From: [Chad Bala](#)
To: [Kelly Bacon \(CD\)](#); [Jeremy Johnston](#)
Cc: [Dan Carlson](#); [Pat Nicholson](#)
Subject: Sweetwater Response
Date: Monday, June 14, 2021 2:37:45 PM
Attachments: [SwtWtr Resp. 6-14-21.pdf](#)
[Swtwtr site plan fn16-11-21 Revised plan copy 2.pdf](#)

Revised Site Plan
Submittal Date
6-11-21

SweetWater CUP		
Agency	Comment	Response
WA State Dept. of Health, Russel Mau		
1	No water provided (via well etc.) No further comments.	Agreed. Project is described with catering requiring water etc. to be brought in for events. If and when water is obtained or transferred the appropriate processes will be followed.
KVFR		
1	Fire Flow Plan: approved by KVFR in terms of access and connections.	On site mtg with KC Fire Marshall on 5-24-21, who reviewed access and conditioned the project to the following regarding Access: 1. Add 2ft of gravel to the driveway which will make it 20ft wide. 2. Entrance is sufficient no need for a 2nd ingress and egress.
2	Facility subject to a 15+minute response time	OK
3	Fire alarm and sprinklers are recommended irrespective of code requirements., This will significantly offset on site water storage and fire flow requirements	On site m

Revised Site Plan
 Submittal Date
 6-11-21

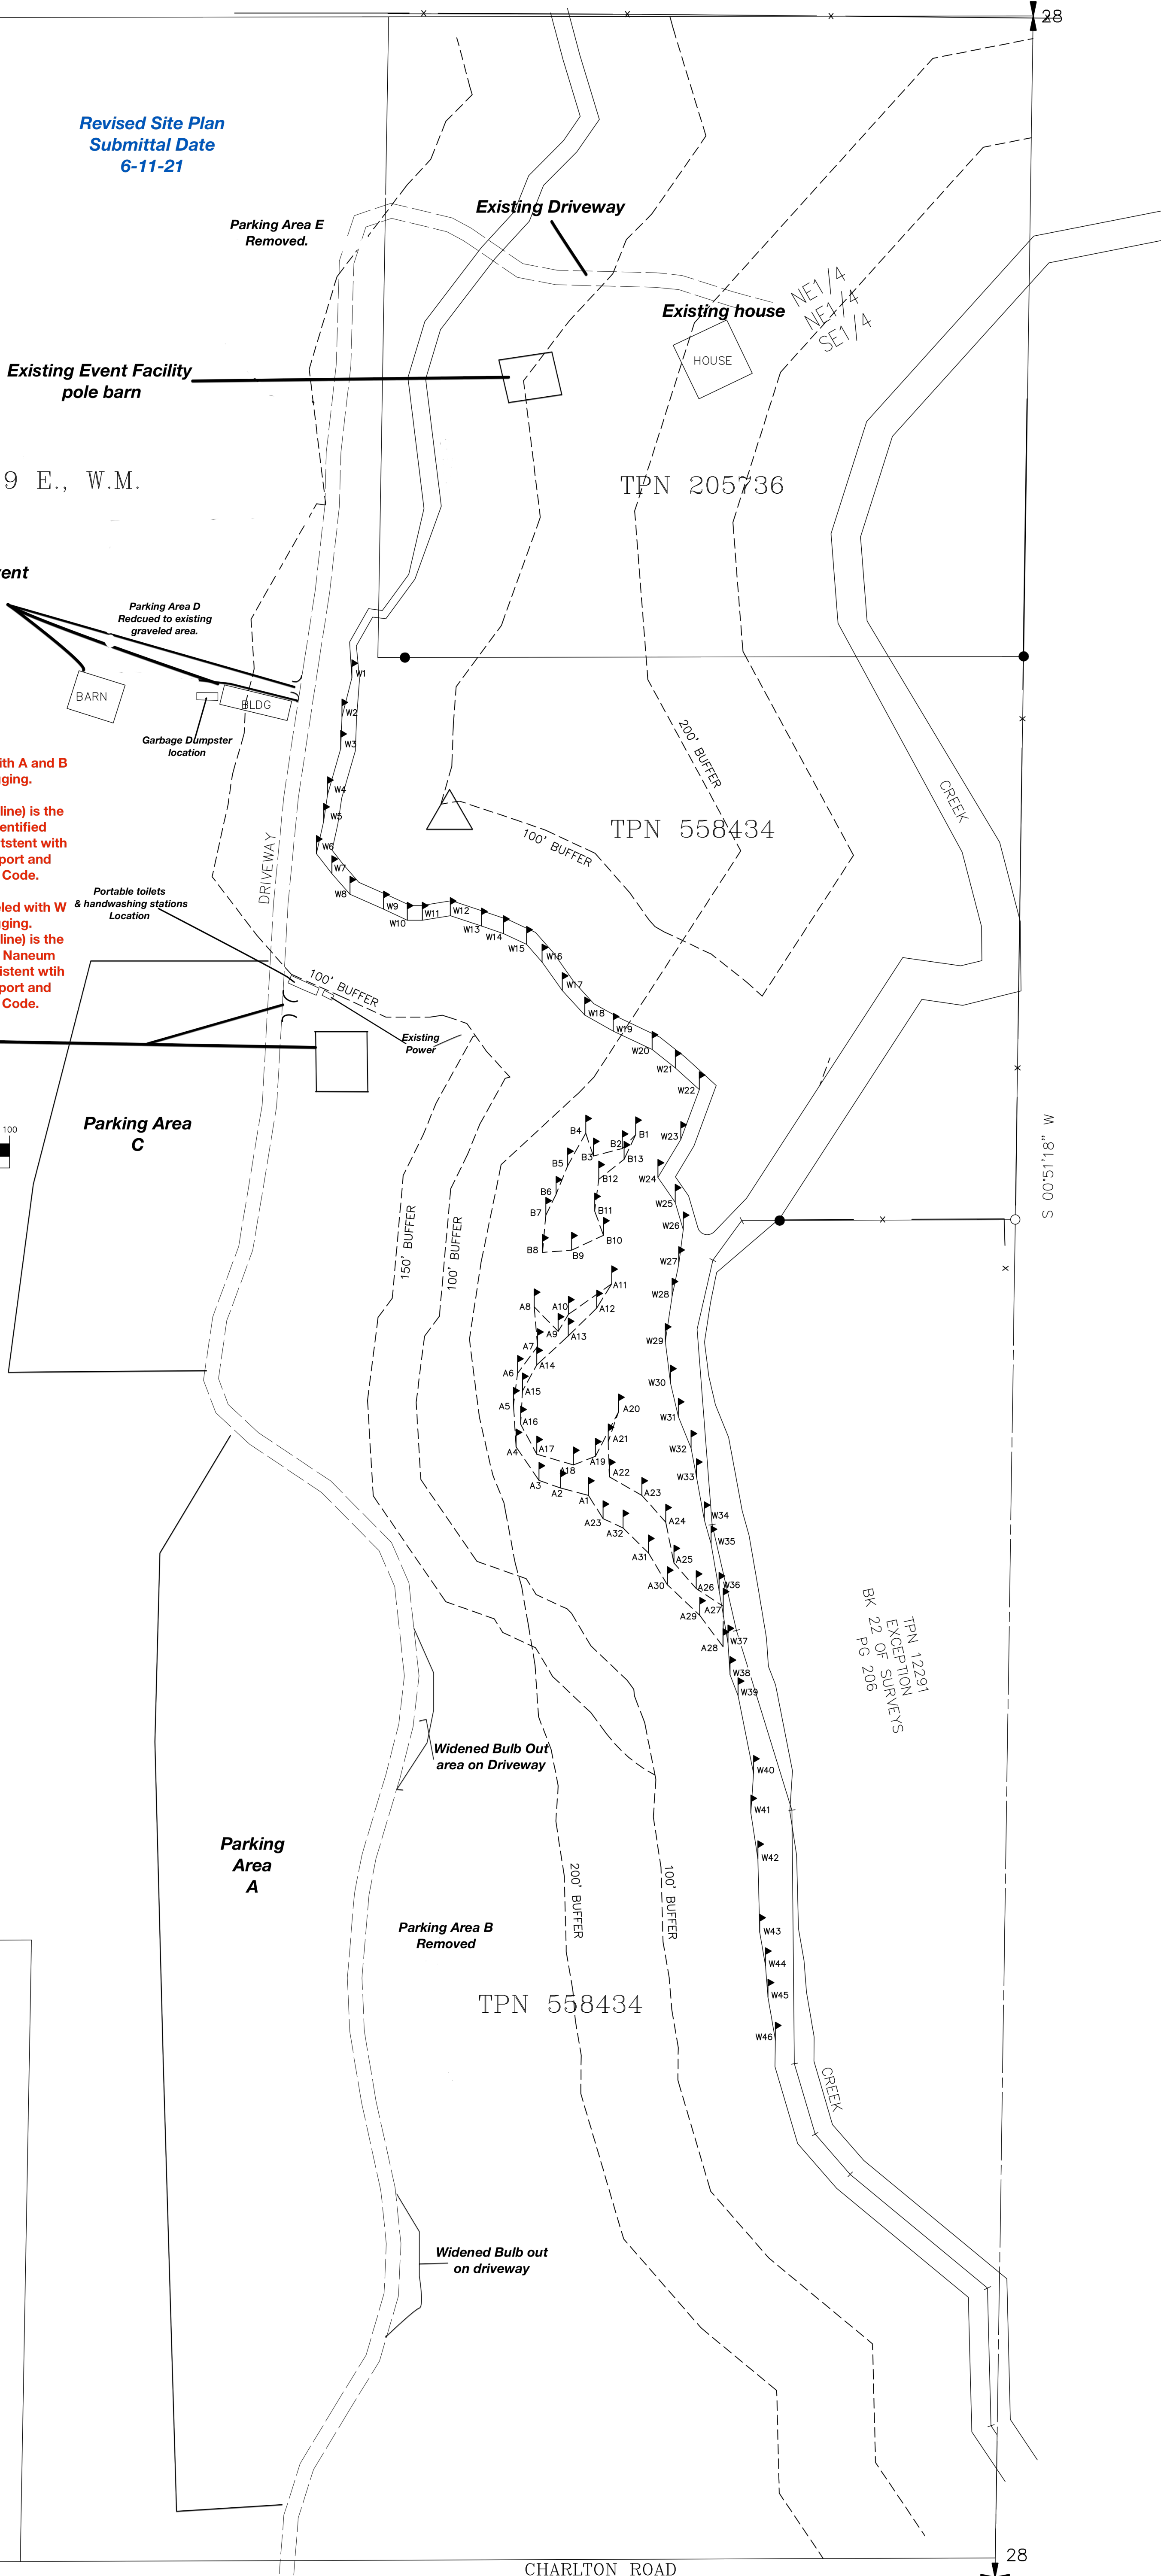
9	Parking Area D is within the shrubsteppe habitat	Parking Area D will not be enlarged as depicted on the site plan. There will be no parking on shrubsteppe habitat within this parking area. With that said there is an existing graveled parking area associated with the existing structures at this location that will continue to be used for those existing structures etc.

10	Parking Area E is within the shrubsteppe habitat	Applicant agrees to remove Parking Area E.
11	Potentially Parking Area C (depending upon the extent) could be within the Shrubsteppe habitat.	Parking Area C is within existing irrigated pasture ground and contains no shrub steppe habitat.
12	From Aerial imagery, there appears to be a drainage with some riparian vegetation that would be impacted. It's stated that this is in irrigation ditch, yet no assessment of current habitat quality or function of that area is described.	The Critical Areas report was completed and identified these irrigation ditches. These ditches convey water to the subject property and to other adjacent properties pertinent to their water rights. Therefore there is no need for an assessment on of these ditches. These ditches within this area have had ongoing maintenance and repair making it more aesthetically pleasing while still providing better conveyance of water to the adjacent landowner.

13	WDFW would like understand the impacts of this drainage for F&W habitat.	The Critical Areas report was completed and identified these irrigation ditches. These ditches convey water to the subject property and to other adjacent properties to the south pertinent to the senior irrigation water rights. Therefore there is no need for an assessment on of these ditches. In fact the existing underground irrigation line has been improved that provides water to the pasture ground around the venue and other surrounding areas.
14	Parking Area B is next a well vegetated area which is identified as an irrigating ditch. WDFW would like understand the connection of that ditch to Naneum Creek.	The Critical Areas report was completed and identified these irrigation ditches. These ditches convey water to the subject property and to other adjacent properties pertinent to their water rights. Therefore there is no need for an assessment on of these ditches. More important and after further review the applicant proposes to remove Parking Area B.

15	WDFW request that these parking areas either be configured to avoid these habitat impacts, or habitat mitigation proposed (such as enhancement of other habitat areas on the property to offset these impacts.	See above changes pertinent to parking areas.
16	WDFW would like to meet on site with the applicant and KCCDS to further discuss the issue of minimization of habitat impacts and/or habitat mitigation.	Ok
17	WDFW request that proposed trails and fire wising extents be shown on the site plan to better understand the impacts and there be no net loss of function form the existing riparian area of Naneum Creek.	The applicant has a right to place trails within the pasture ground and grass area around the event facility or for that matter on their property.
18	If habitat impacts are expected, then habitat mitigation in the form of riparian enhancement in other areas of the riparian area to offset impacts are requested.	The existing structures are within existing pasture ground etc. These structures are outside of the required buffers that were established in the Critical Areas Report and consistent with Kittitas County's Critical Areas Code. Furthermore these existing structures are outside of the adopted shoreline boundary designation and all have been constructed under existing/approved building permits with Kittitas County. With the aforementioned, and since the existing structures are located in an existing pasture etc. mitigation will not be needed.

The following has been revised on the site plan:

1. Parking Area E has been removed.
2. Parking Area D has been reduced down to the existing gravel parking area associated with the structures and round-pen at that location.
3. Parking Area B has been removed.
4. Driveway (bulb outs) have been added along the driveway per Fire Marshal direction.
